From: Simon Davis
Sent: 09 October 2026 14:57
To: 'Jack Karagoz' [REDACTED]
Cc: Rebecca Hornsby [REDACTED]
Subject: WA/18/26/PL - Land off Arundel Road Fontwell

- No more than 32 of the dwellings hereby approved shall be occupied unless and until the applicant/developer supplies a certificate confirming the agreement of the Royal Society for the Prevention of Accidents (RoSPA) for the proposed play area and the play-as-you-go trail on the eastern side of the site which are all adjacent to the A27. The submission shall include details of any physical changes, if necessary, for approval in writing by the Local Planning Authority prior to occupation.
- Reason: In the interests of amenity and safety in accordance with Arun Local Plan Policies D DM1 and OSR DM1.

Drawing Title
Block Plan

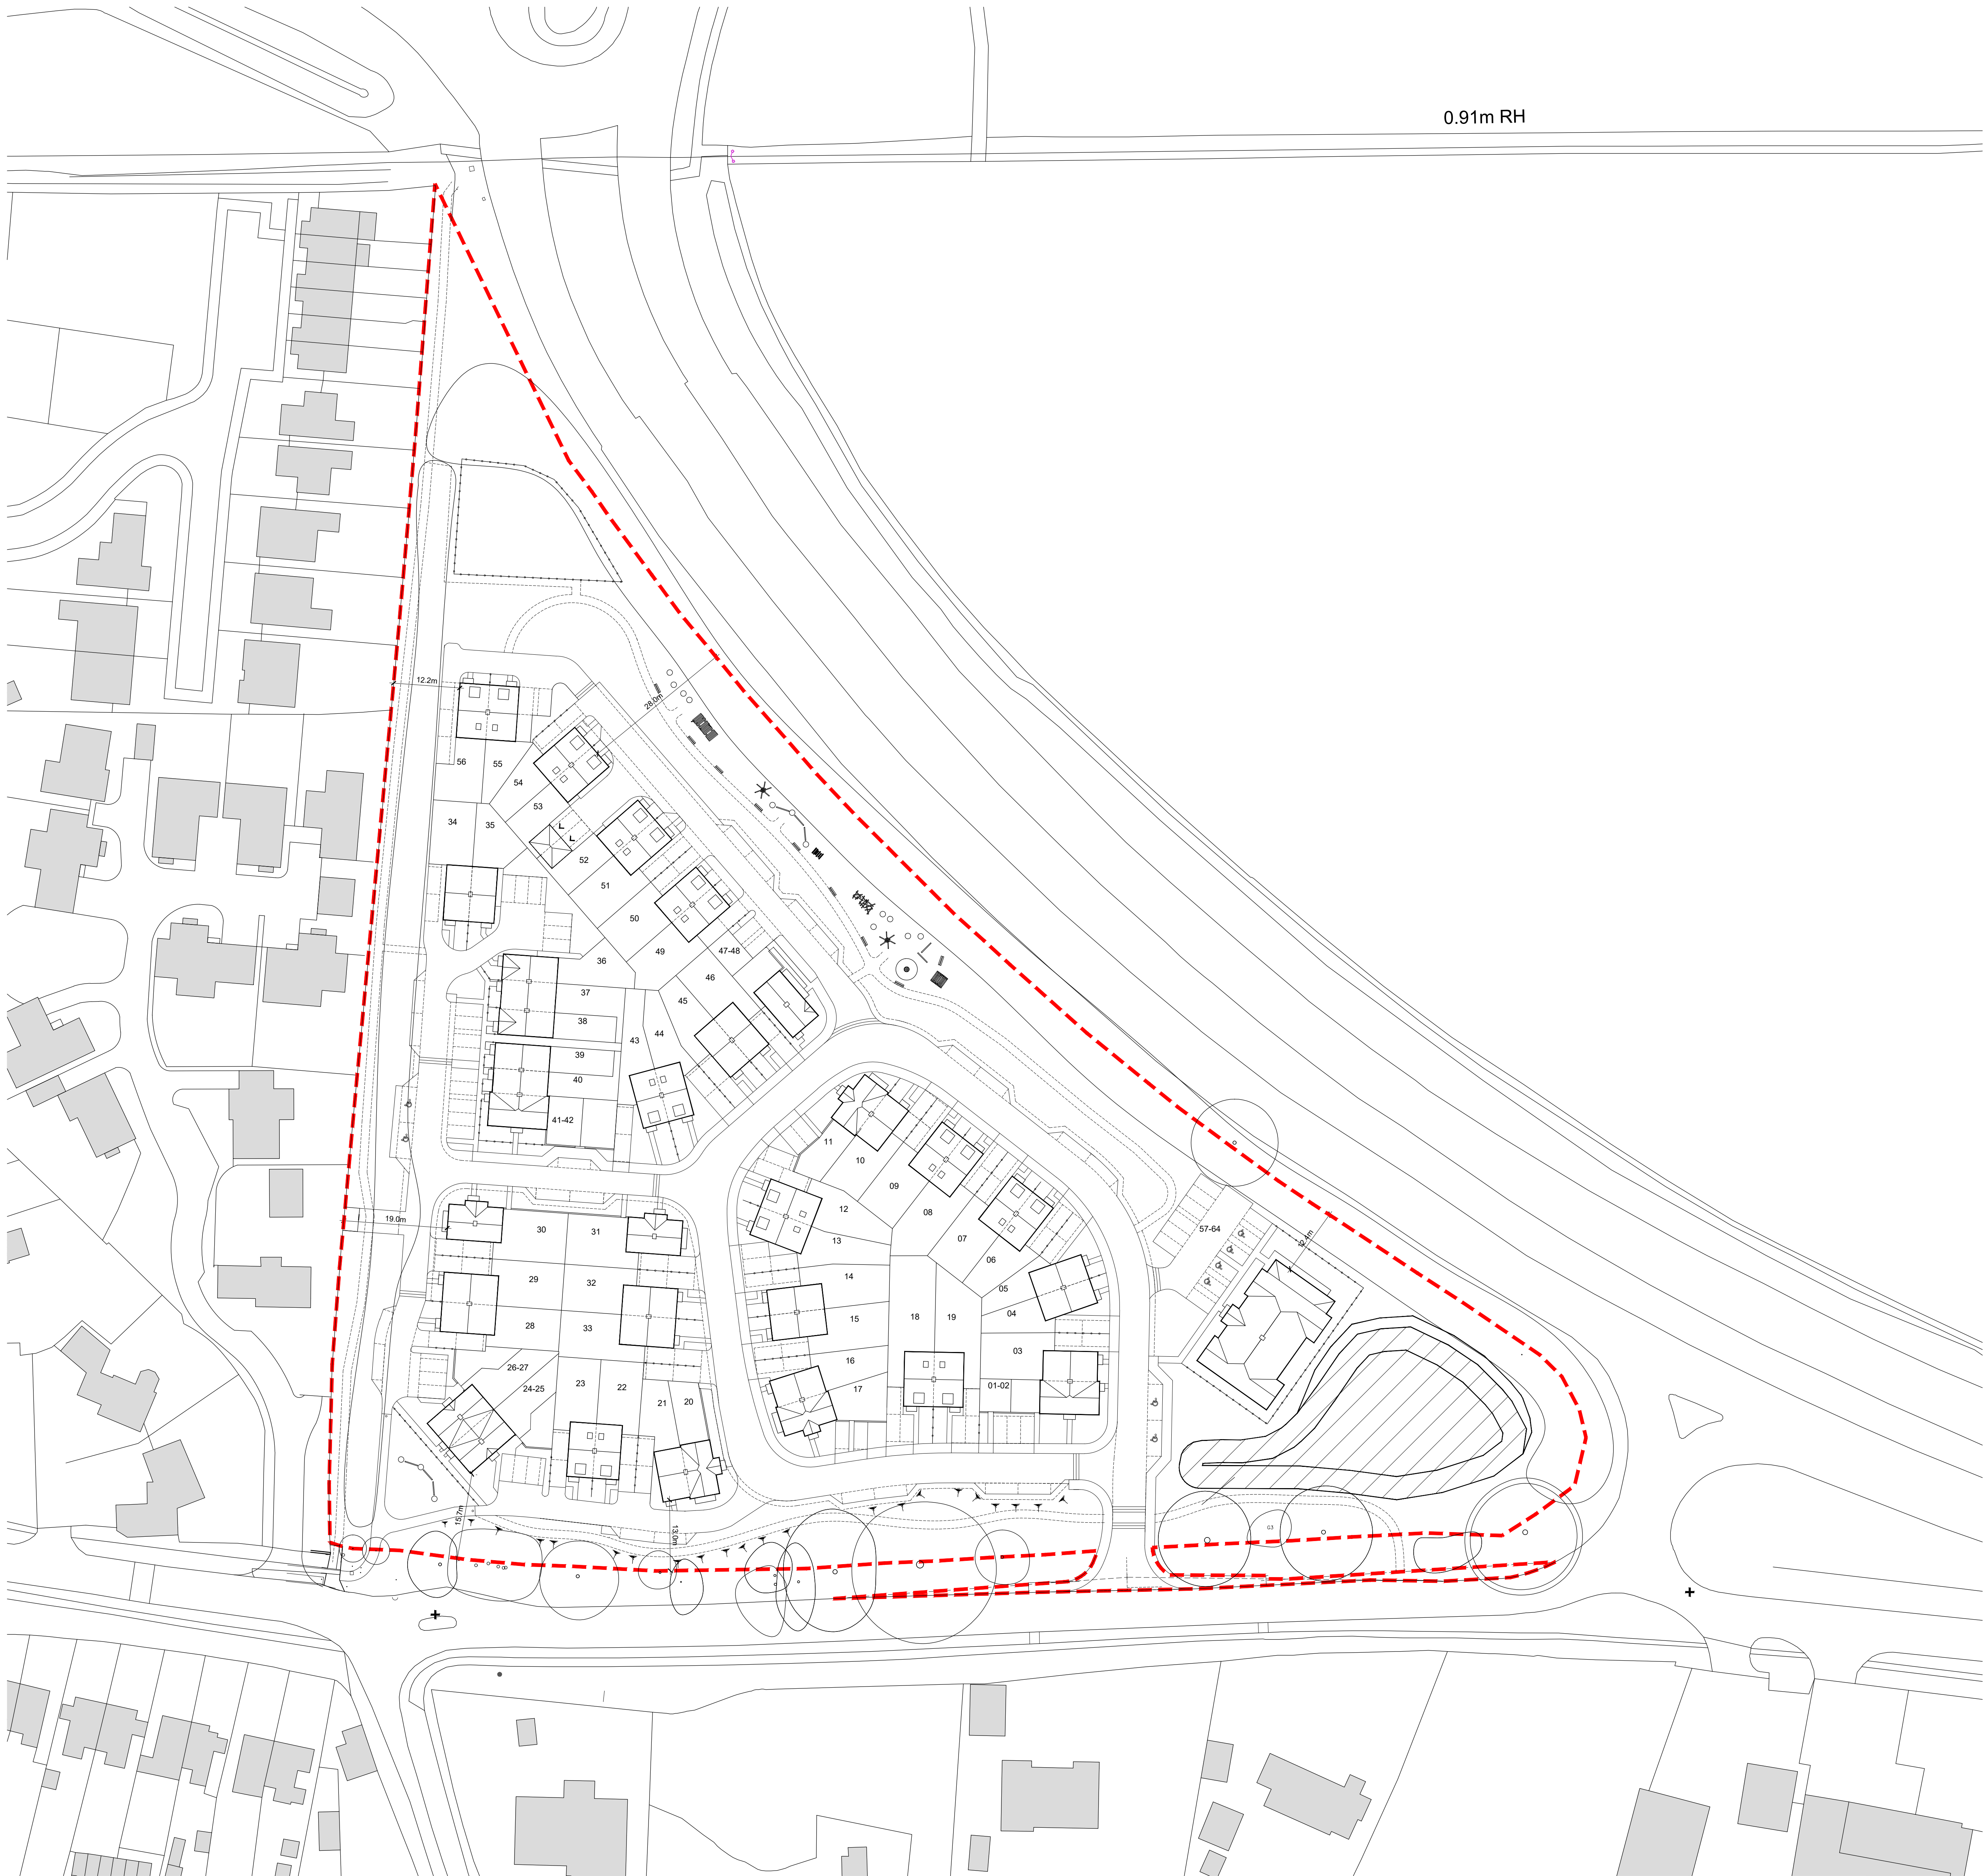
I spoke to Matthew (Woodhead) last week and mentioned we have our Members Briefing Panel soon. That was today and members made some points about the safety of children using the play areas given the proximity of the A27 in terms of the risk of kids getting onto the A27 (noting recent unfortunate events) and/or vehicles crashing off the A27 and onto the site. I made the point that the play area would be fenced but that wasn't enough in members eyes.

Therefore, I have said that we will impose an additional condition requiring ROSPA certification for the play areas. I also note that I didn't include a boundary treatments condition in the recommendation. I am therefore going to recommend the inclusion of these two (see below) in my written report update to the Ctte. Do you have any comments on these? It would also be useful to get your comments on how this risk will be reduced.
